## Submission in response to proposed Pitt Street North Over Station Development (SSD 18\_8875)

This Heritage Submission has been prepared in conjunction with a submission by Navon Solutions on behalf of the NSW Masonic Club, 169-173 Castlereagh Street, Sydney, to the Department of Planning and Environment in response to the proposed Pitt Street North Over Station Development (OSD).

The Concept Development Application presents *Planning Envelope Drawings* and *Indicative Scheme Drawings* documented by Architectus. Both sets are reviewed below.

Figure 10: North-South Section showing proposed OSD and the NSW Masonic Club in blue

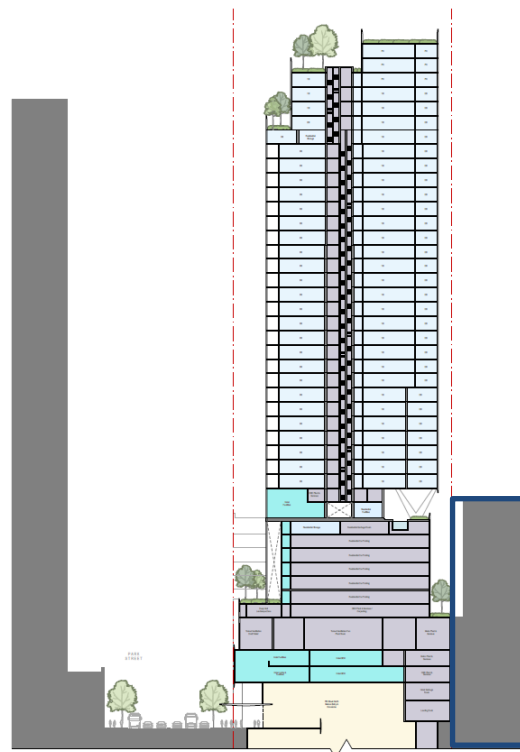
The north south section within the drawing set illustrates the proposed podium from ground level to level 5 as built hard to the Club's southern boundary. Figure 8 indicates the location where this section occurs. The section does not describe the setback that also occurs along this boundary of the Club due to the indented floor plan.

The floor plans of the Club are best illustrated in Figures 13 and 14. The indent in plan along the north and south boundaries create setbacks to both sides. The application does not include a section that describes this condition, which is the primary sectional condition.

The *Indicative Scheme Drawings* presented in Appendix F: Urban Design and Built Form of the application presents inaccurate setback information between the proposal and the NSW Masonic Club's southern boundary between ground and level 6. The north south section in the application indicates the Club has a zero setback at these levels. The Club's floor plans show there is an approximate setback of 1.6-2.2m. The proposed podium design should respond to the high significance of the NSW Masonic Club and provide an equal setback, that is a 2.2m setback over these levels to act as a mirror to the setback of the Masonic Club Building.

The construction of the Pitt Street North OSD is an opportunity to reinstate the historical pattern of development that occurred on Castlereagh Street. The Grand Dining Room is a highly significant room. A building constructed with nil setback to the southern boundary will reduce light into the Dining Room and maintain the adverse impact on the significance of the room first imposed by the Stockland Building. This is an opportunity to reinstate the original level of natural light to the Grand Dining room through the provision of an equivalent setback on the Pitt Street North OSD site.
